# **SAVE OUR SANDLINGS**

**Offshore Wind Farms  
EAST ANGLIA ONE NORTH PINS Ref: EN010077  
&  
EAST ANGLIA TWO PINS Ref: EN010078**

**Issue Specific Hearing 4  
Wednesday 20<sup>th</sup> January 2021**

**Responses to Issue Specific Hearing 4 held 20<sup>th</sup> January 2021 via Microsoft Teams****Agenda item 5 Onshore Traffic and Transport****Friday Street junction<sup>1</sup> Works area 36.**

Annex 4: Work No. 36

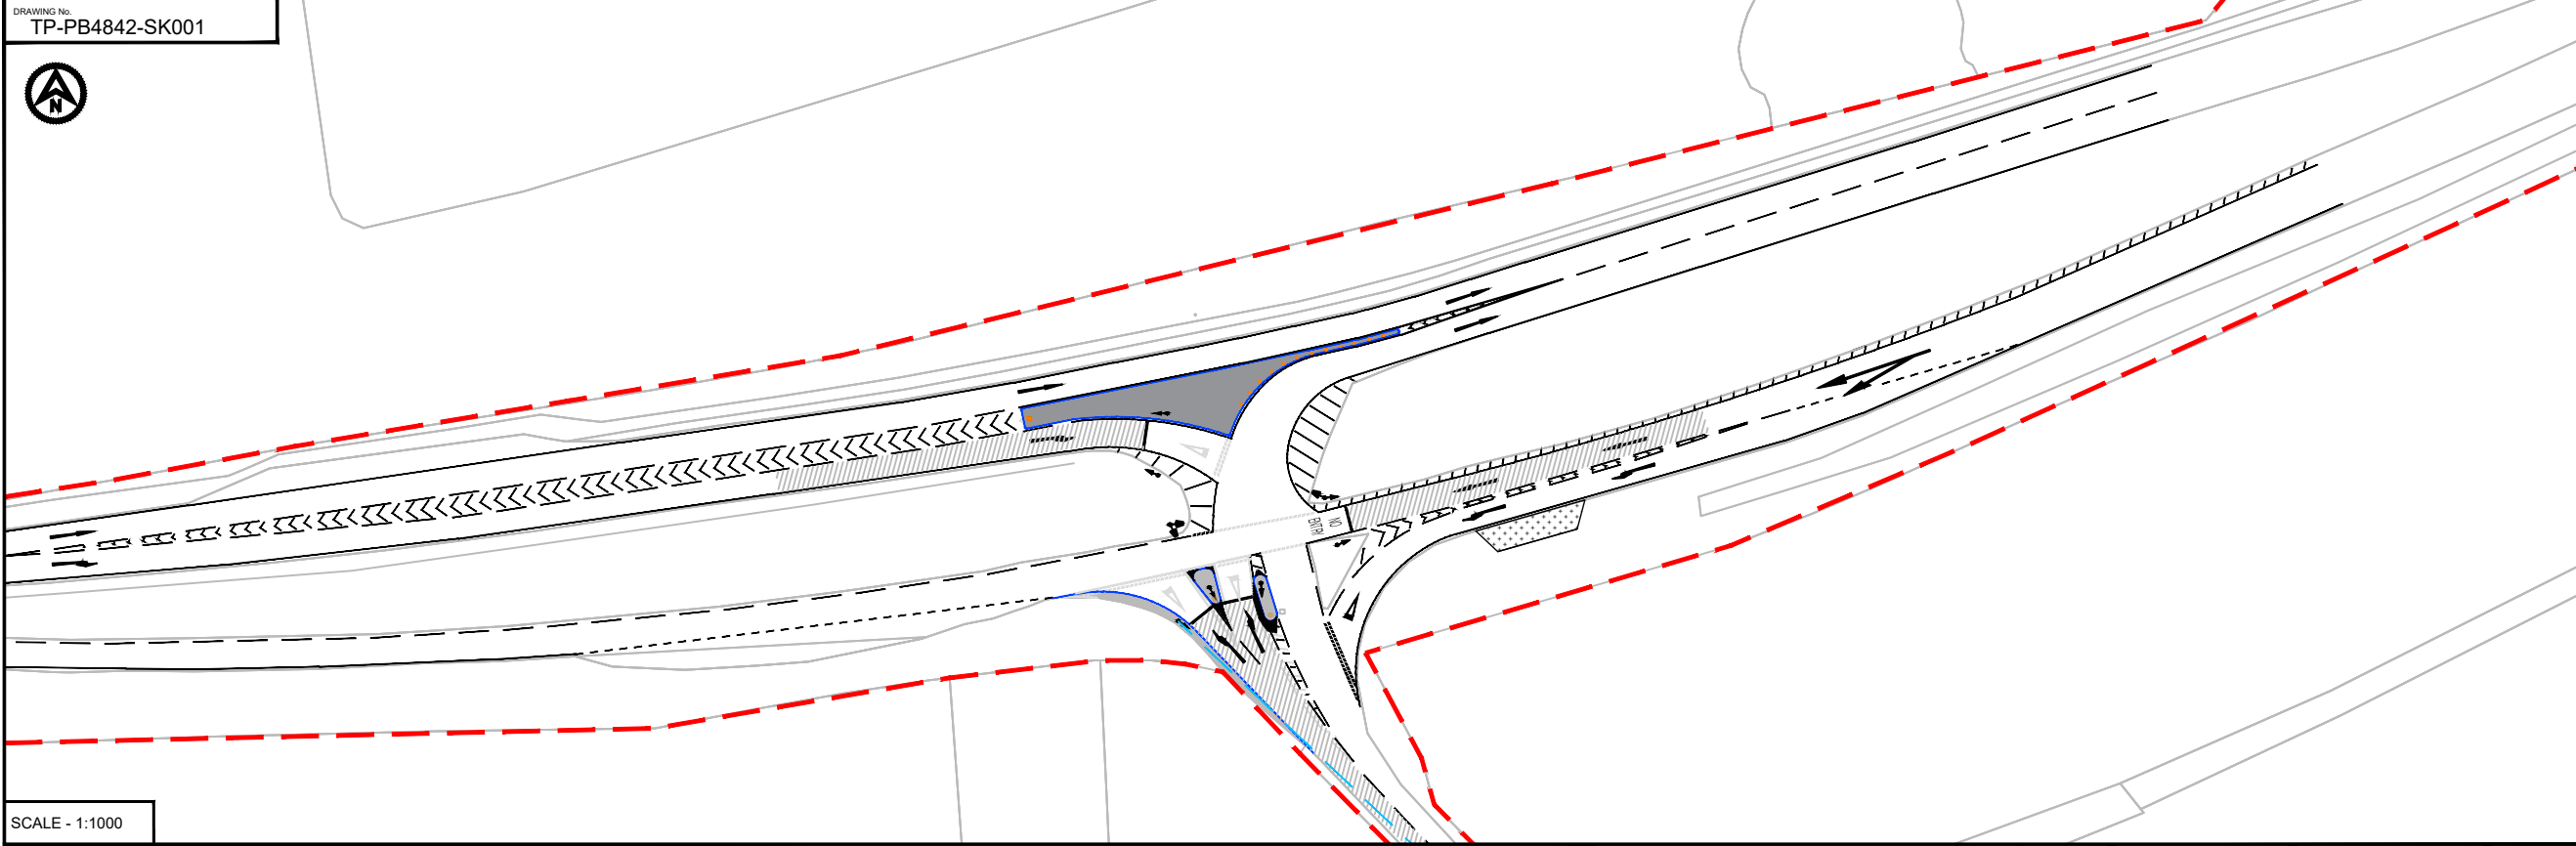
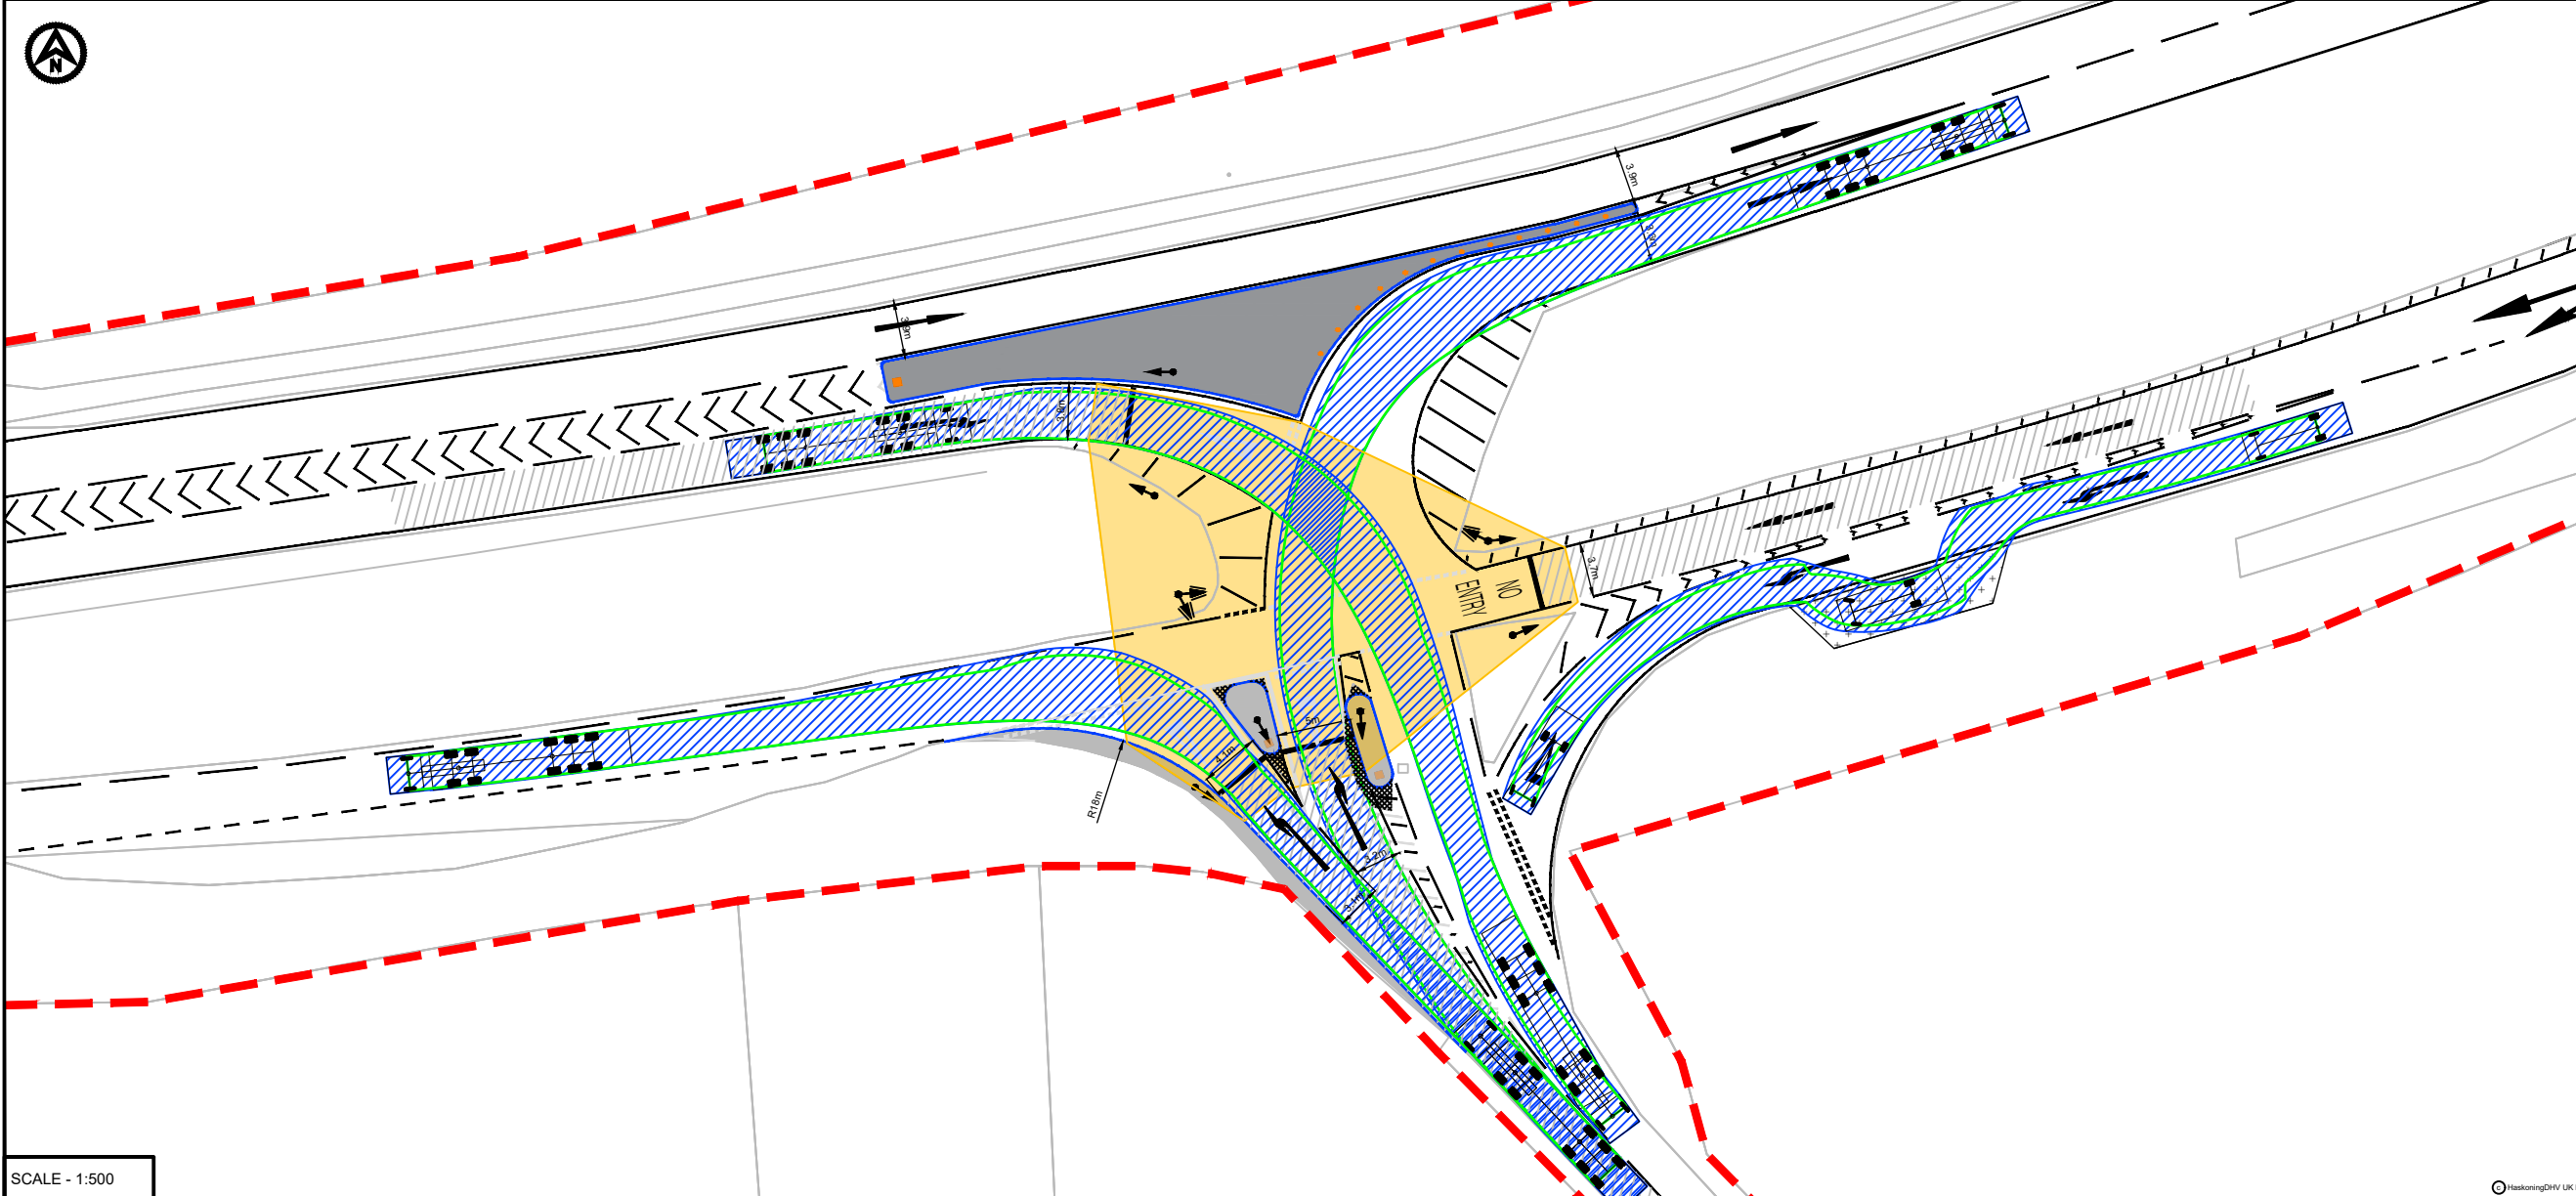
This is a problem junction for local residents and visitors alike as it has an unusual and confusing layout for traffic turning right from the A 12 north onto the A 1094, and traffic turning right from the A 1094 onto the A 12 northwards. The layout is such that traffic from the more minor A 1094 has priority over right turning traffic from the major A 12 trunk road. This junction has been the source of very many accidents in recent years, though not all have been recorded statistically as some result in minor 'fender benders' and are resolved between parties without recourse to insurance claims and not recorded in the source of the tabulated results<sup>2</sup>. Whilst the addition of some form of traffic management may help to limit further traffic collisions, the introduction of signals controlled traffic may lead to increased delays and accidents unless signals are very carefully phased with demand or become inoperative. We are of the opinion that a 3 arm roundabout provides a better and safer solution than the current proposals for the following reasons:

- ii. During high peak flow times, traffic waiting to turn right onto the A 1094 from the A 12 can queue beyond the end of the filter lane, aggravated if there are a significant number of

priority vehicles waiting to turn right from the A 1094 onto the A 12 northbound. When there is a large volume of traffic travelling south on the A 12 with no significant gaps between vehicles severe delays result leading to impatience and frustration and ultimately poor decisions and risk taking. This junction confuses a great number of visitors and users. There is a stop line for right turn vehicles (A 12 – A 1094) with the option for one vehicle to enter the junction and wait at a 2<sup>nd</sup> stop line. On many occasions an additional vehicle enters the junction impeding a right turn from the A 1094 to the A 12, leading to yet further frustration, hesitation and potential road rage. Ideally, this should become a yellow box junction ensuring a free flow of vehicles at all times. Unfortunately, a number of visiting users are less courteous towards local road users and employ the cut and thrust tactics of city driving.

We consider that a 3 arm roundabout provides a much better solution than traffic signals to the many problem issues of this junction and we do not accept the consultant's conclusion that temporary traffic lights provide an adequate solution to traffic issues.

The road approaching from the North reduces from 2 lanes to one, with the nearside lane becoming a left turn filter. The road from the South is single carriageway merging into 2 lanes with lane 2 becoming a right turn filter. Issues begin when traffic turning right from the A 1094 onto the A 12 are uncertain how to merge with faster flowing A 12 traffic in the nearside lane, or move straight over into the nearside lane. Less confident drivers hesitate and alter speed and/or slow down causing a great deal of uncertainty for other road users of their intentions.

Issues are compounded by the fact the lay-by on the A 12 Northbound carriageway is alongside the right turn filter lane to the A 1094. It is possible for traffic joining the A 12 from the A 1094 to be unaware of vehicles leaving the lay-by and a potential for collision.

For all of these above reasons we do not believe the conclusions to implement temporary traffic light control at the A 12 – A 1094 junction with no additional junction alteration/remediation will aid traffic flow or reduce potential collisions during the construction. Rather we believe the additional

works related traffic will only exacerbate the already overloaded road network contributing additional delays and impairing road safety and severity of this collision cluster.

A 3 arm roundabout will offer the following benefits not only to local residents and frequent users of this junction, but will simplify and improve safety for irregular and first-time users especially as roundabout junctions are familiar to all UK drivers

- A roundabout design naturally results in a reduction in speed of A 12 traffic approaching the junction allowing greater safety for all traffic and lessening the collision risk

- Traffic turning right from the A 1094 onto the A 12 has priority over traffic from the left and can safely merge onto the A 12 Northbound.
- Traffic turning right from the A 12 to the A 1094 has priority over Southbound A 12 traffic, but will give way to traffic from the A 1094

- Traffic turning left from the A 1094 onto the A 12 can merge onto the A 12 when safe to do so.
- A roundabout will also allow vehicles to make a 180 deg. turns which whilst not encouraged at present have been observed on several occasions.

- Traffic merging onto the A 12 Northbound from the lay-by may do so in safety, giving way to traffic on the roundabout.
- A result of Eastbound turning traffic flowing more freely will result in a reduction in the likelihood of queues obstructing the A 12 Northbound.
